Recommendation Report for Planning Permission for Works or Extension to a Dwelling

REF NO: F/7/22/HH

LOCATION: 8 Beagle Drive
Ford
Arundel
BN18 0NY

PROPOSAL: Alterations to existing outbuilding.

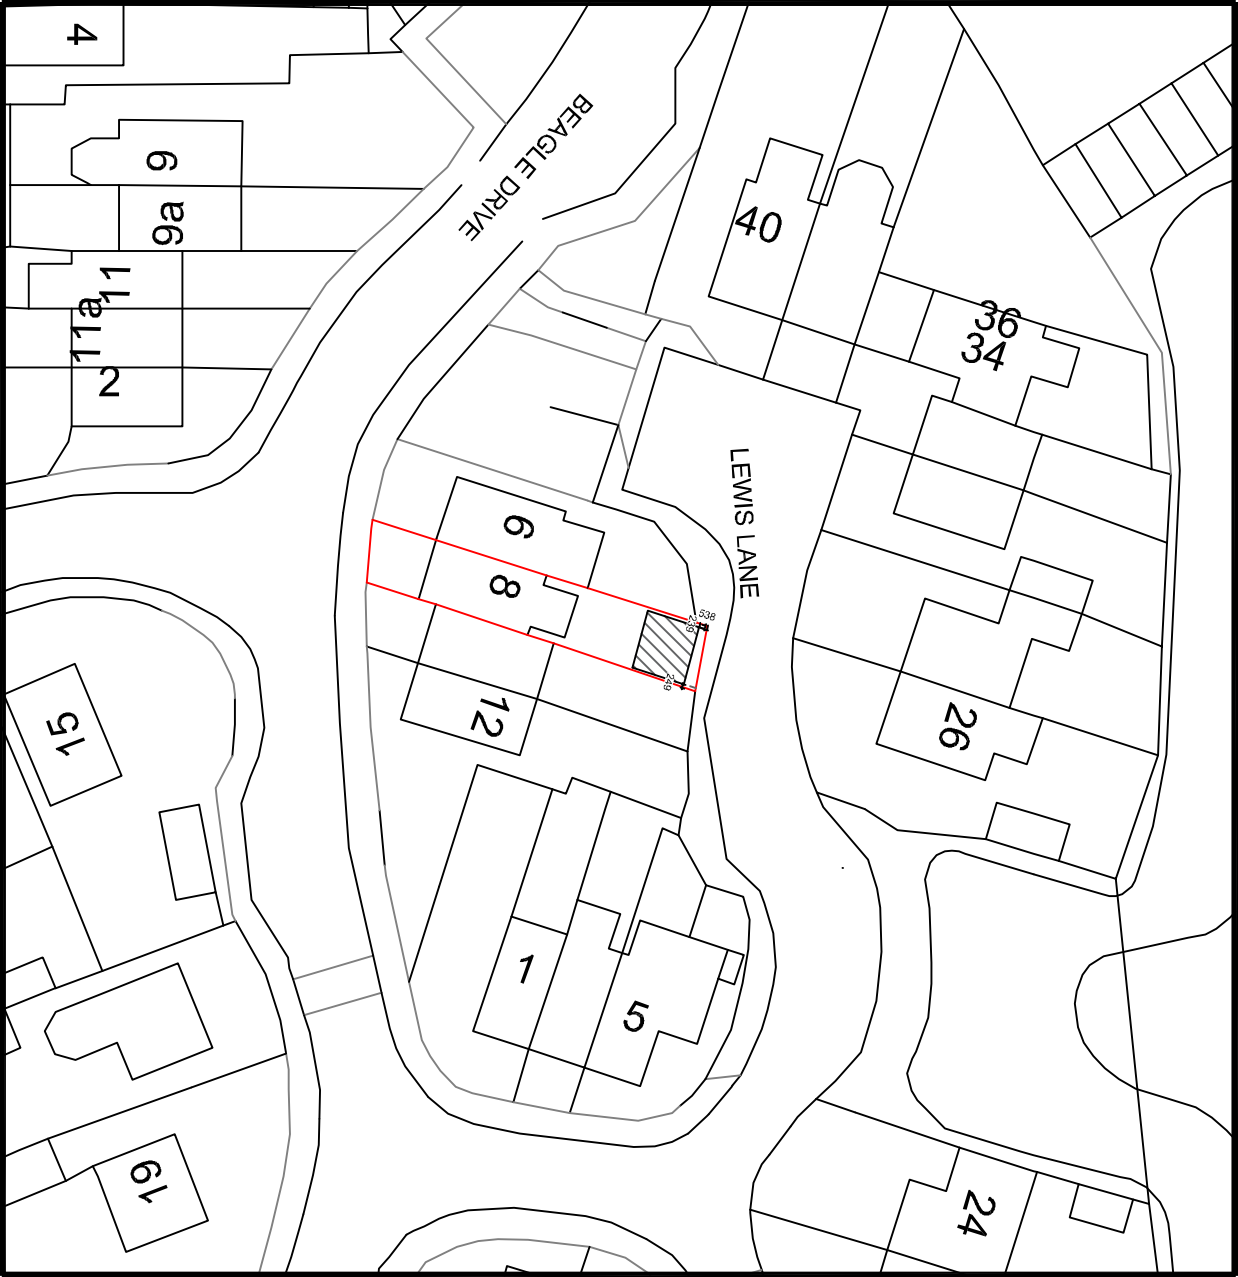
This is a resubmission of F/25/21/PL seeking amendments to the size of the retrospectively approved outbuilding. This application seeks to make the building 430mm shorter in length, to bring the whole construction back within the curtilage of the property further to comments received from WS Highways for the previous application.

Comments received from highways as part of F/25/21/PL stated that the workshop may be partially positioned on highways land (grass verge), the application redline previously included the grass verge. Highways suggested a 'stopping up' order be undertaken so as to protect the safety of the highway in accordance with policy T SP1. In this application the applicant has chosen to amend the size of the outbuilding rather than apply for a 'stopping up order', as such Highways comments have now been addressed as the whole structure is located within the curtilage of the dwellinghouse.

The application building as amended will now not affect Highways land as such the building now complies with Policy T SP1 of the Arun Local Plan.
